**Hanson Tweed Sand Plant Expansion (SSD-10398)
Environmental Impact Statement (EIS)**

Mitchell Isaacs
Chief Knowledge Officer
Department of Planning, Industry and Environment: Water
18 June 2021

Detailed advice to DPIE Planning & Assessment regarding the Hanson Tweed Sand Plant Expansion (SSD-10398)

FIGURE 11: GROUNDWATER DEPENDENT ECOSYSTEMS

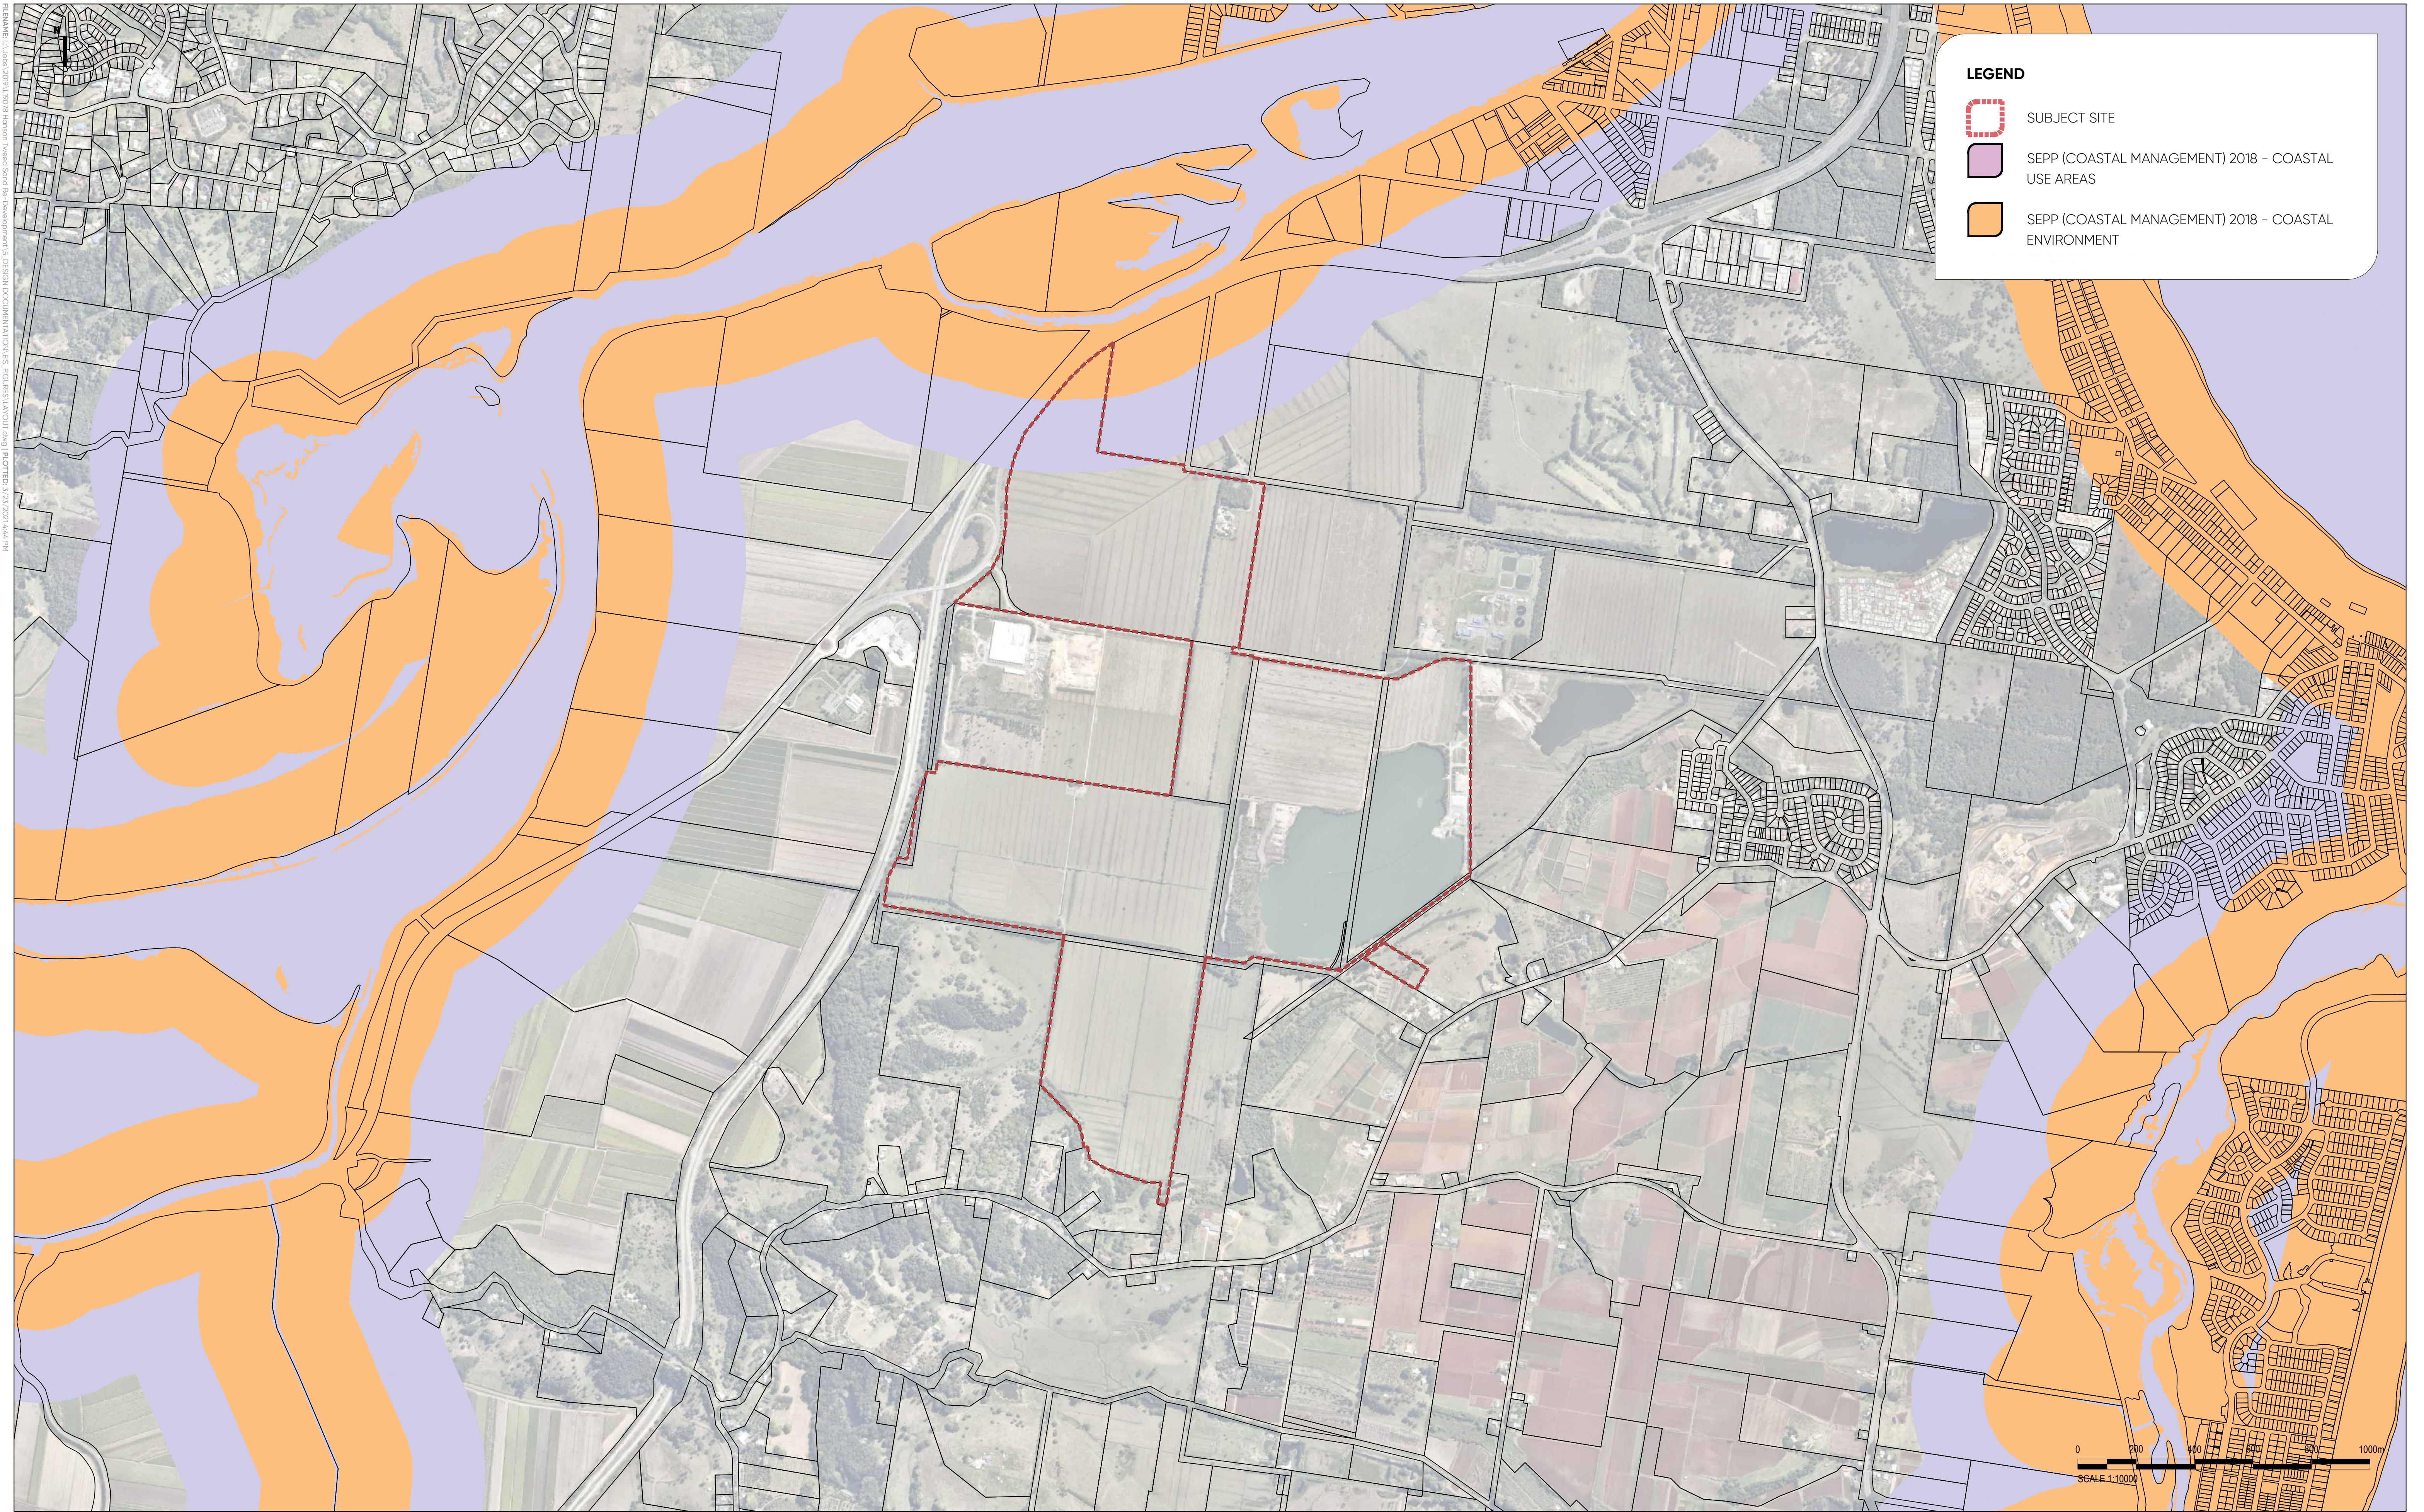
The proponent's EIS has not referenced the Water Sharing Plan for the 'North Coast Coastal Sands Groundwater Sources 2016' to identify 'high priority' GDEs.

DPIE data shows 'high priority' GDEs located along the southern boundary of the existing extraction area. These GDEs have not been referenced in the EIS. The groundwater model drawdown contours presented in the Groundwater Assessment shows water table impact as a change from the already developed site conditions. The drawdown contours present no predicted change in water table at the

location of the 'high priority' GDEs identified in this review. The AIP GDE impact criteria is cumulative impact and impacts from the existing site development along with the project expansion must be considered.

- a) present a supplementary report addressing the 'minimal impact considerations' of the NSW Aquifer Interference Policy (2012) with consideration of all high priority GDEs, DPIE Water's observation on salinity and iron concentrations and potential impacts,
- b) analyse and report on lake salinity risks post closure,
- c) quantify the risk of water quality changes and their impact on GDEs, including the increase in soluble iron.

FIGURE 19: EXTRACTION PHASES

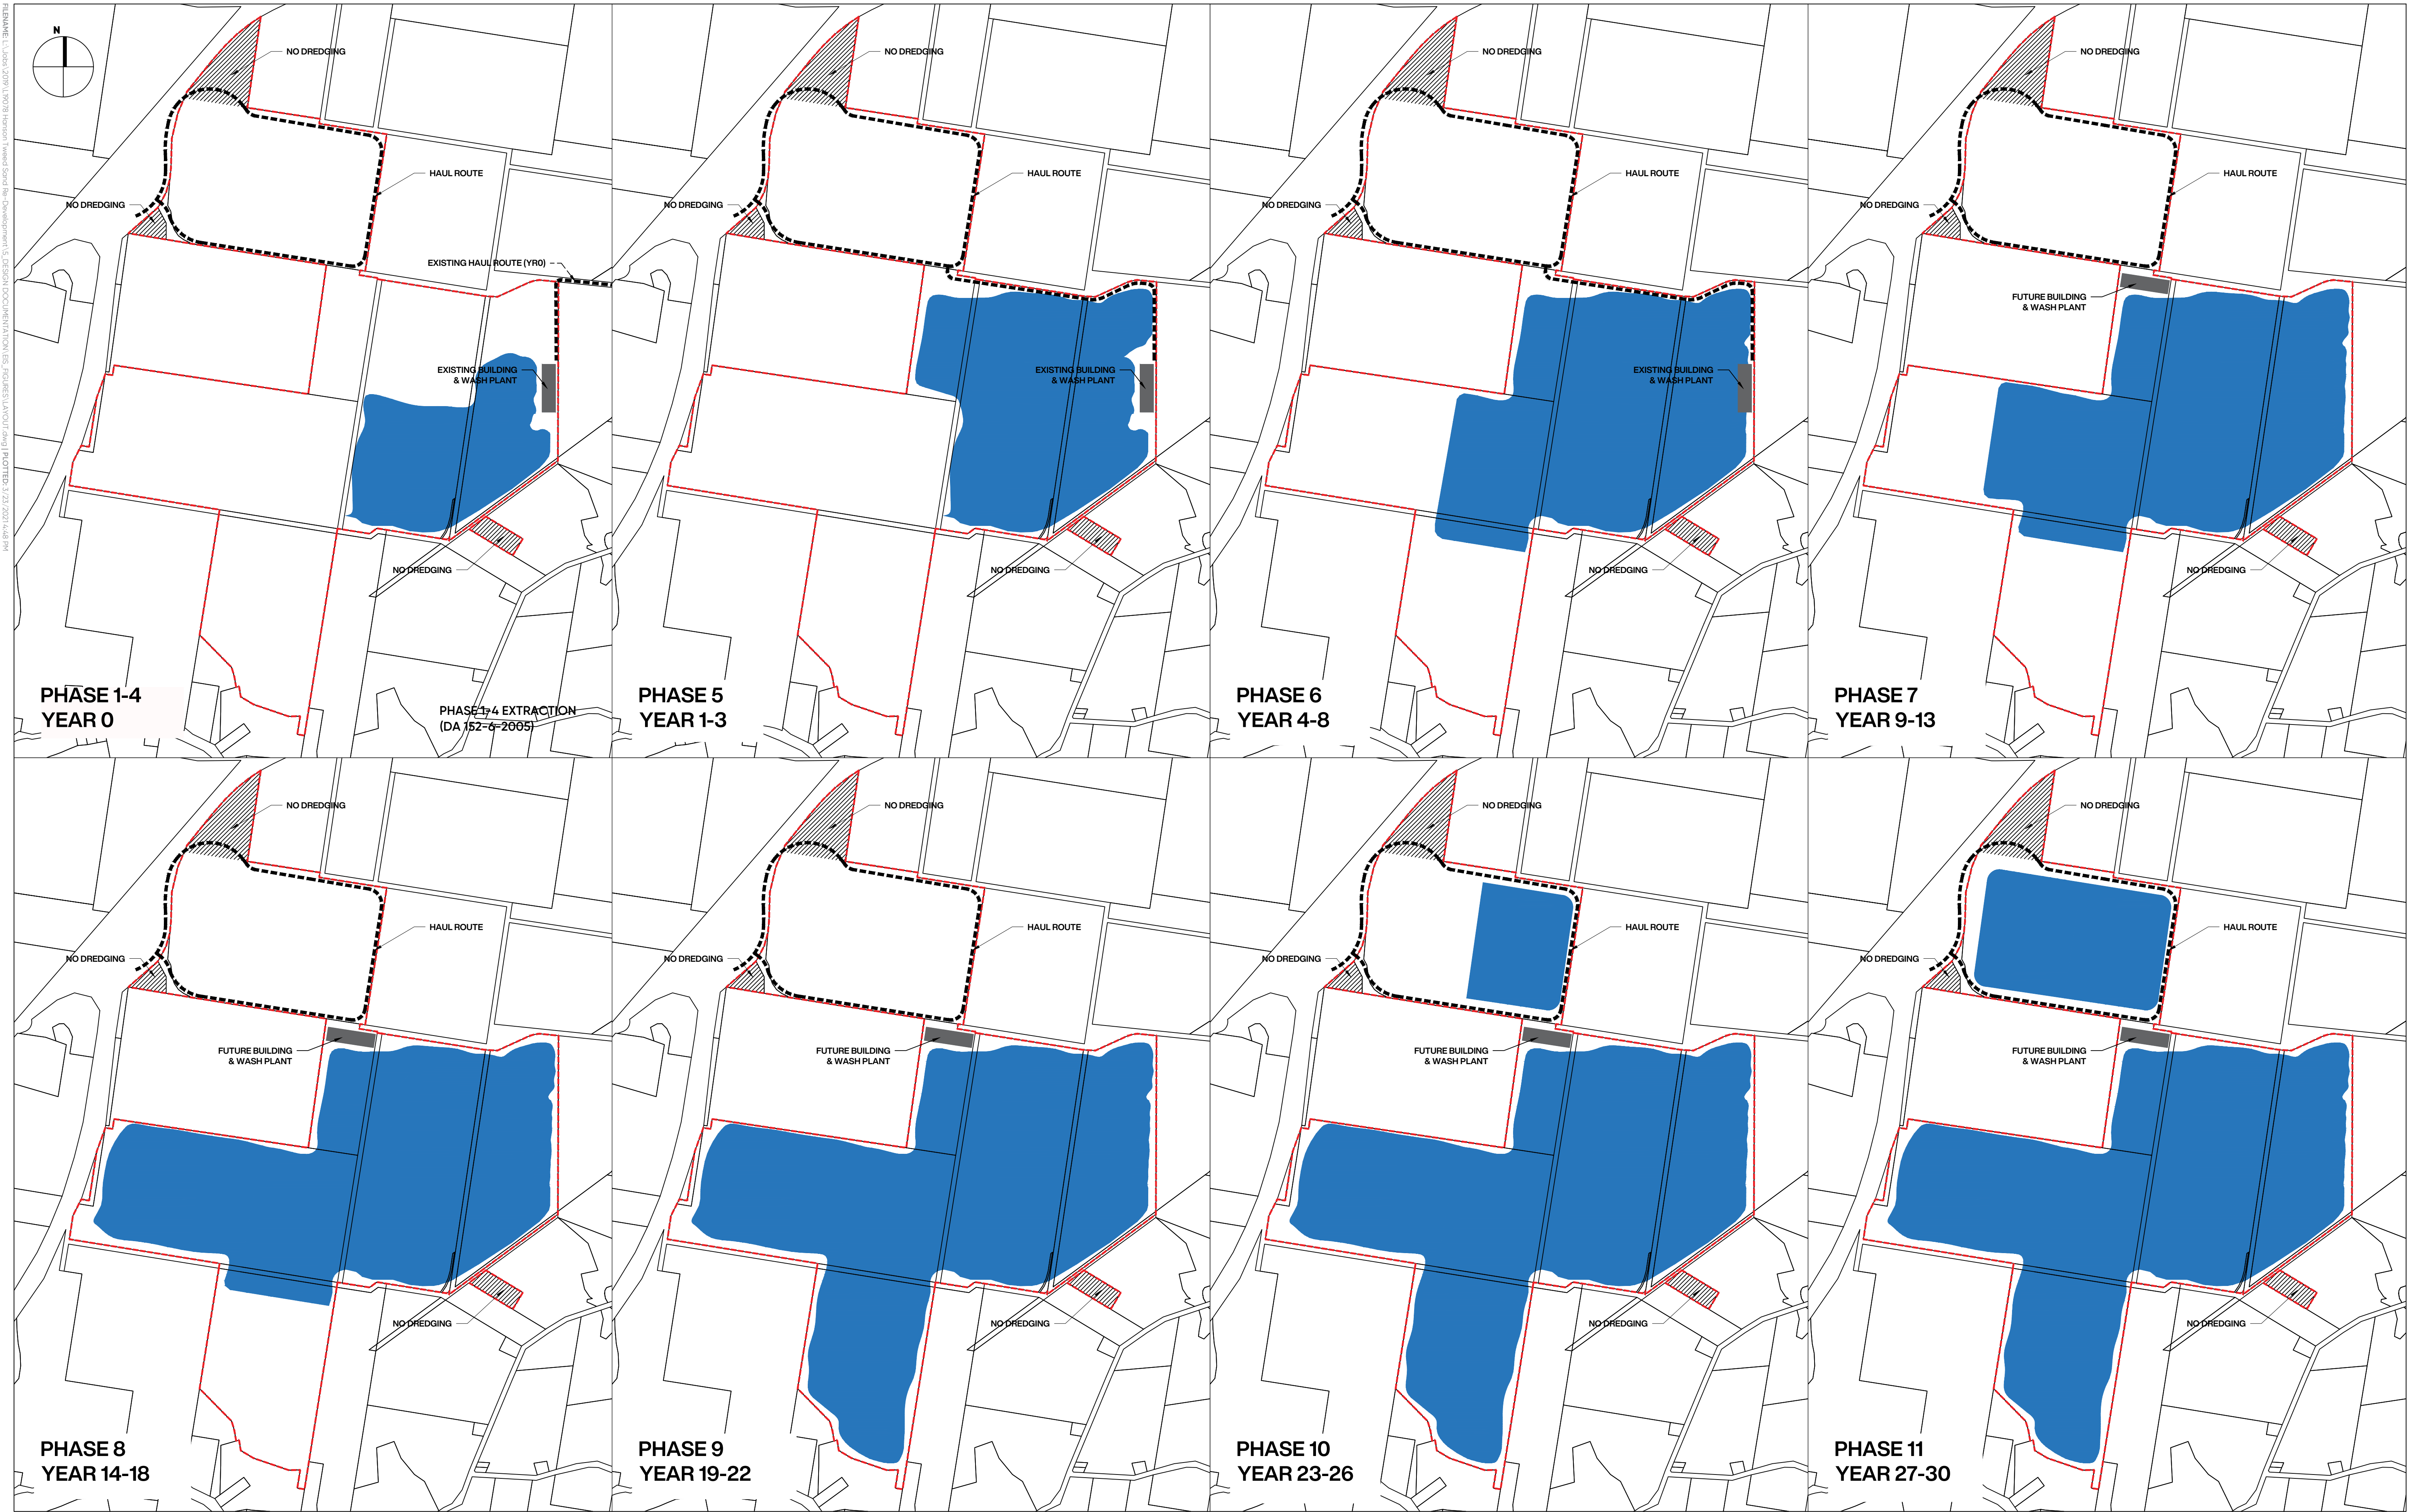
The proposed expansion of the lake to the south in Phase 6 is to intercept diversion drains for external catchments (catchment 2 and 3) to the south east which will result in additional runoff entering the lake, rather than being diverted around the site. Appendix B of Appendix D1 of the EIS indicates Catchment 2 has a catchment area of 34.6ha and Catchment 3 an area of 68.2ha. It is not clear what the potential annual runoff volume is to be captured within the southern lake from these catchments, however it is recognised to be significant based on the predictions of increasing the median water level from 0.4mAHD to 0.67mAHD.

- a) quantify the annual volume of surface water take due to runoff from external catchments 2 and 3 for a range of climatic scenarios (wet, average and dry),
- b) quantify the annual volume of surface water take due to flood events that result in water entering the lakes and water being captured above the standing water level of the lake, and
- c) demonstrate sufficient entitlement can be acquired in the relevant water source to account for the maximum take. If insufficient entitlement can be acquired it is recommended that the proponent consider:
 - i. alternate layouts to enable runoff water to be diverted around the site, either with diversions and/or with dams constructed under the harvestable rights of catchments 2 and 3, and

- ii. redesign of the lakes outlet system to enable them to be detention basins during a flood event and that any water captured can be released immediately after.
